Our ref: HA/2019/121650/01-L01
Your ref: BN/52/19/HH
Date: 08 October 2019

GROUND AND FIRST FLOOR REAR EXTENSION AND ALTERATIONS.

BROOK COTTAGE LAKE LANE BARNHAM PO22 0AD

DRAWING 2A

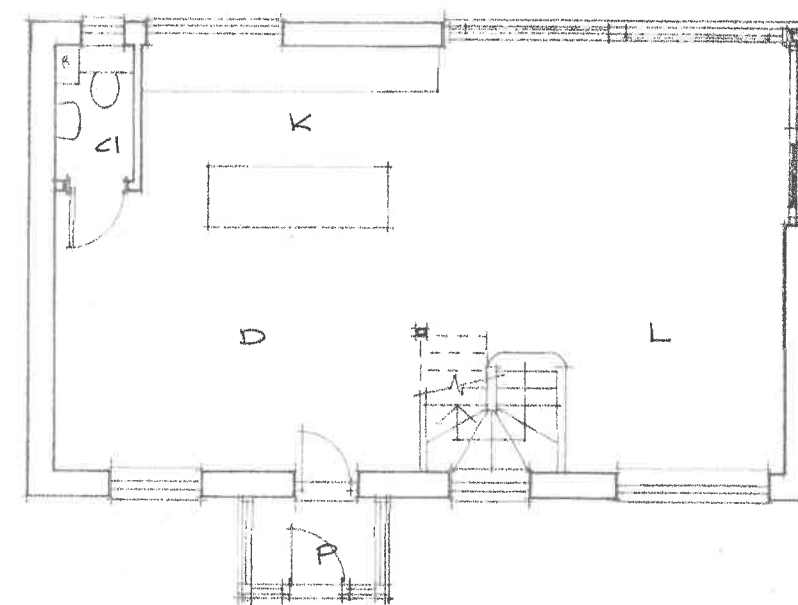
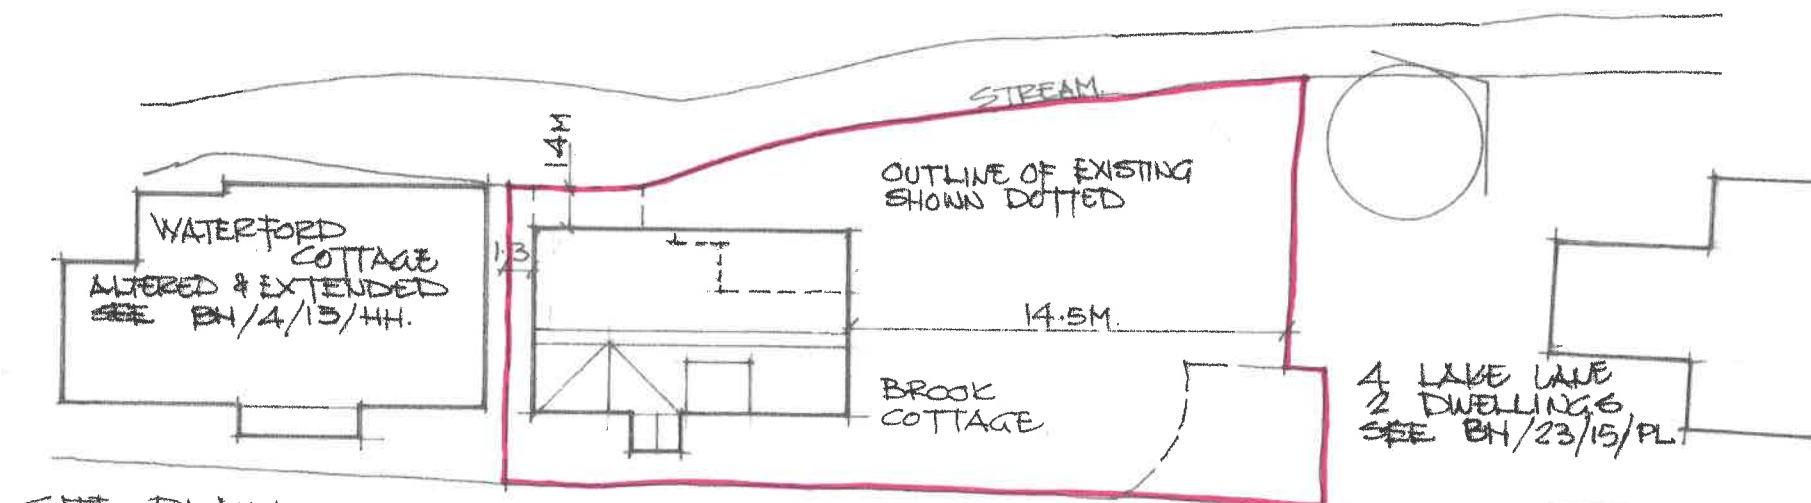
It appears from the site drawings that although this is a proposal for an extension of the property, that the footprint of the building in relation to the stream is actually reduced with the rear ground floor protrusion to the stream bank top being removed.

This being the case the applicant should ensure that during construction no materials are allowed to enter the watercourse and the retaining bank of the stream should be left as natural as possible, to provide a suitable buffer and wildlife corridor. Ideally this buffer should be left to naturally colonise, but if planting is required then only naturally occurring native species should be considered.
